Proposed Development at: 7 Orchard Close, Cuffley, Potters Bar EN6 4QD
Application Reference: 6/2016/0233/FULL

We wish to object to the proposed development as there is an inconsistency between drawing numbers 1118 131 and 1118 132 as submitted by the applicant regarding the position of the proposed building in relation to the site. It is therefore impossible to ascertain exactly where the proposed new 4 bedroomed property will be sited in relation to our own house.

Client	Mr J Ricotta
Site address	7 Orchard Close Cuffley, Potters Bar, EN64QD
Project Description	Erection of a new two storey dwelling
Drawing Title	Site Plan
Drawn	JR
Checked by	DP
Issued for	Planning approval
Scale	1:50@A3
Drawing No.	1118 132
Date	February 2016
Revisions	..... ..... ..... .....

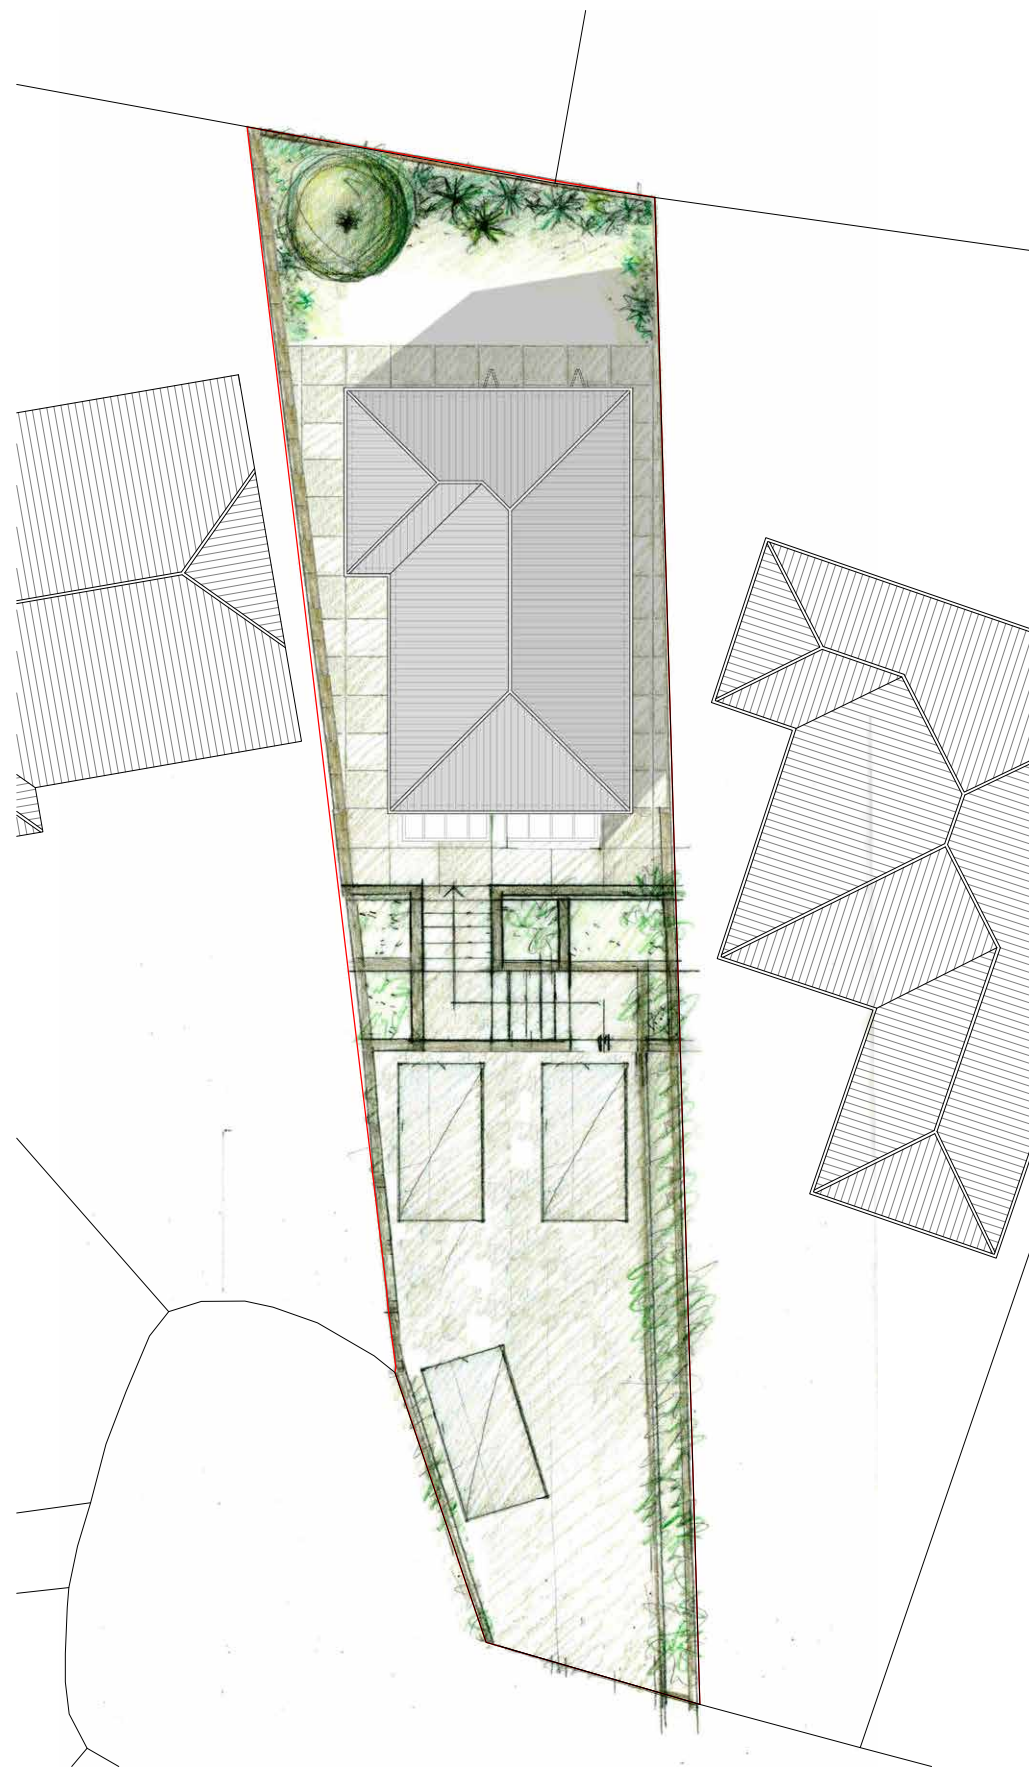
If, on the other hand, the siting of the new house as shown by drawing 1118 132 is what is intended (i.e. the footprint of the proposed development is virtually the same as that of the existing house excluding the current garage) then we have no objection in this respect.

We attach for your convenience annotated copies of drawings 1118 131 and 1118 132 from which you will clearly see, in particular, that in the former drawing the back of the proposed building is set forward from our own, giving a larger back garden, whereas in the latter drawing it is virtually in line with the back of our own property.
